Date: 07/31/2024

Re: Plan Issue
Location: Lot 49 Mason Ridge (49 Calebs Corner Place (Spring Lake, NC))
JDS Project No.: RDU2407808
Date of Inspection: 07/31/2024

A representative of JDS Consulting arrived on site to observe the issues reported to us by the client, which are presented, along with our recommendations, in this report.

2ND FLOOR LAYOUT

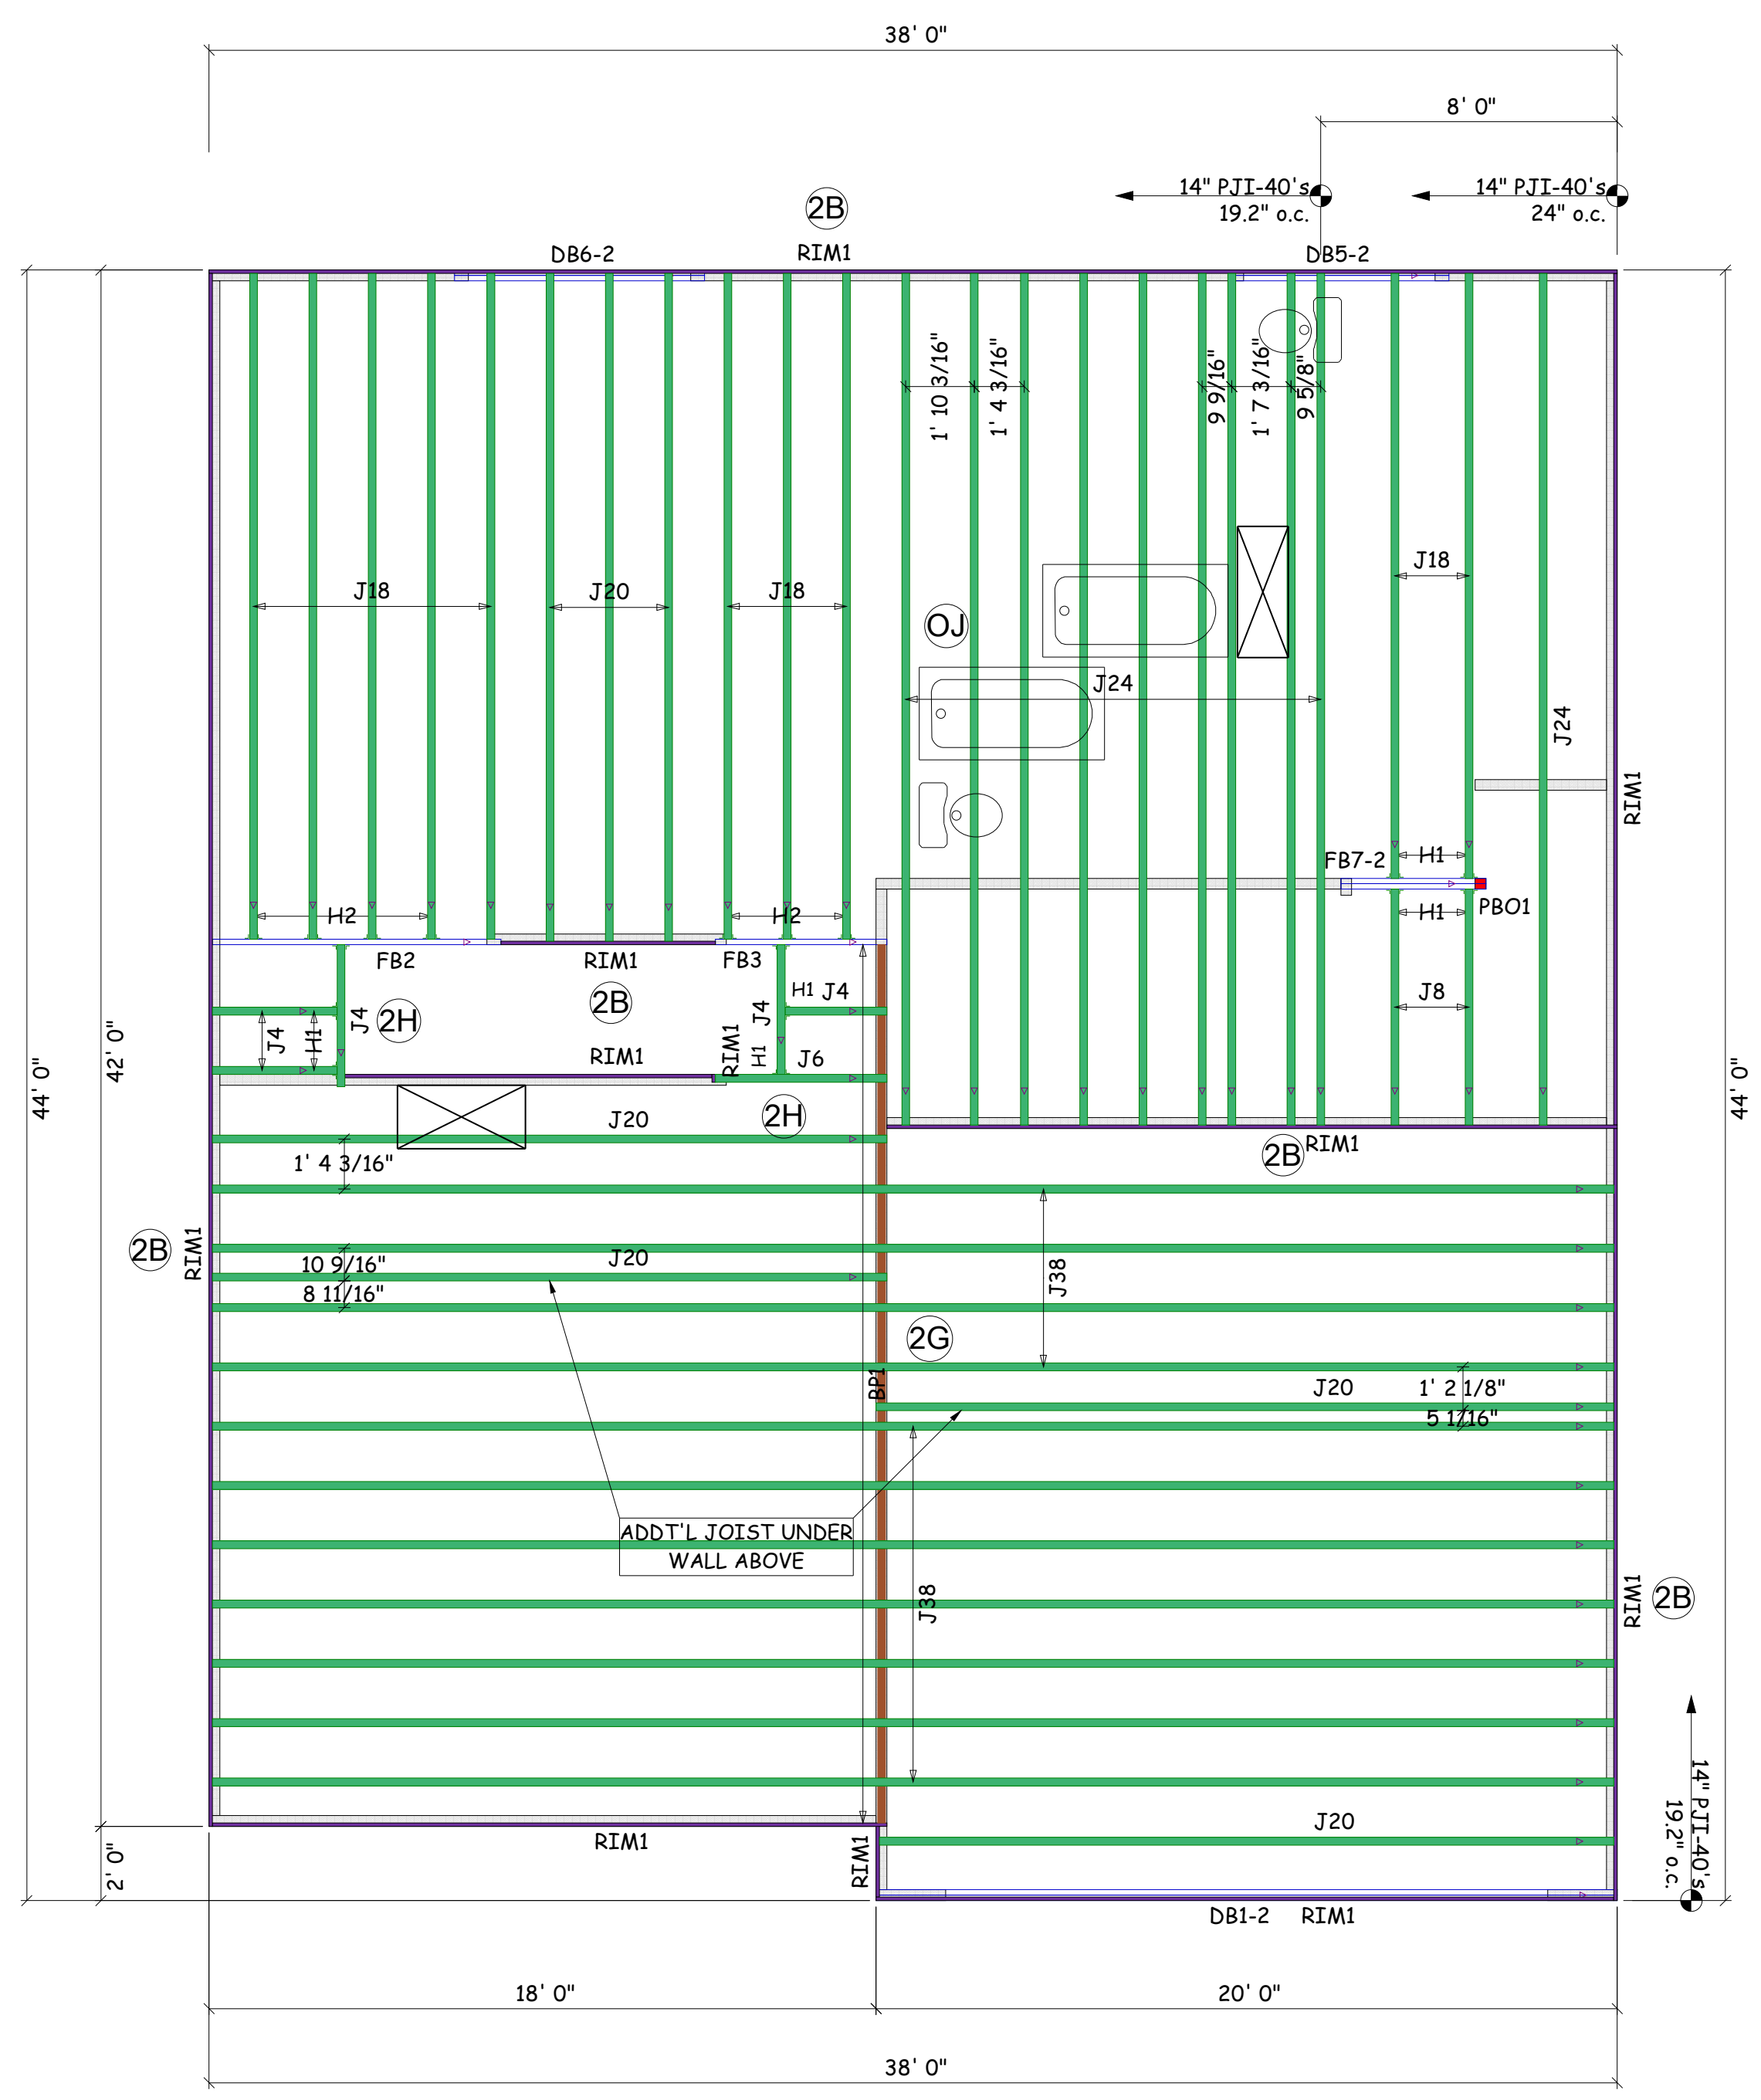
Client requests an evaluation of the 14" LVL behind the stairs. Plans specify a double I-Joist at that location, a 14" LVL was installed.

Based on our on-site observation and review, the existing 14" LVL is adequate as installed. No further repair is required.
